Our Ref: R/61/19/PL

**Town & Country Planning Act 1990 (as amended)
Town and Country Planning (Development Management Procedure) (England) Order 2015
Application for Planning Permission**

Development Change of use from museum & cafe to single dwelling. This application may affect the character & appearance of the Rustington Conservation Area.

Location Church Farm Cottage 76-78 The Street Rustington

Scale: 1:1250 | Area 2Ha | Grid Reference: 505084,102305 | Paper Size: A4

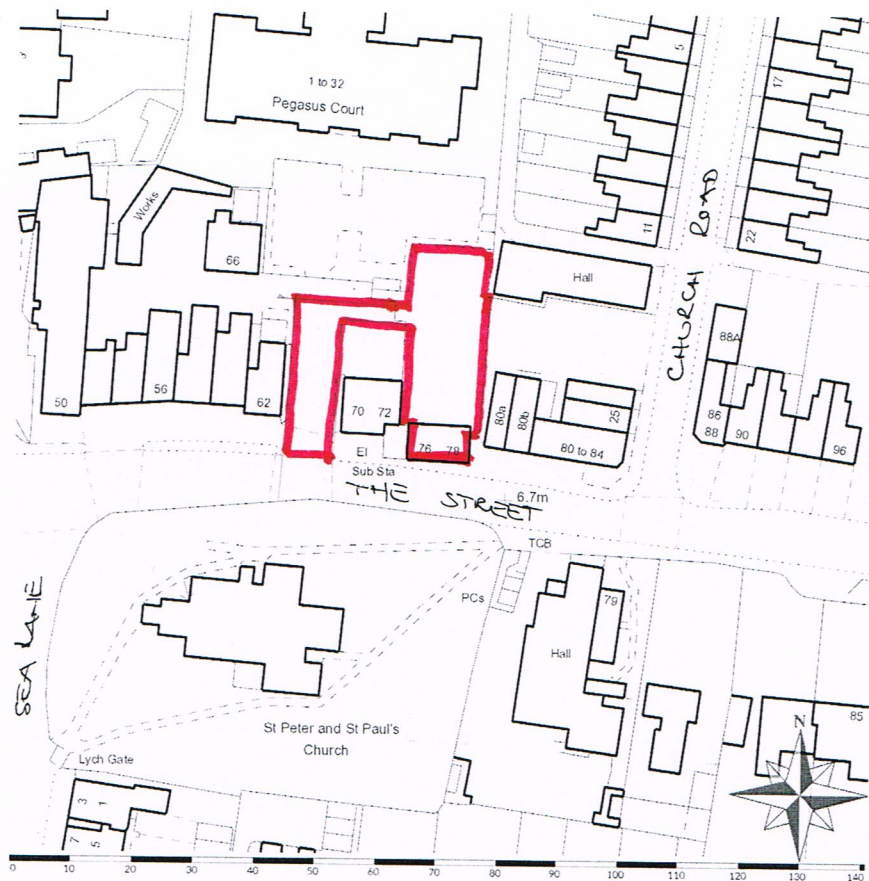
Location Plan Amend

Please provide two named roads.
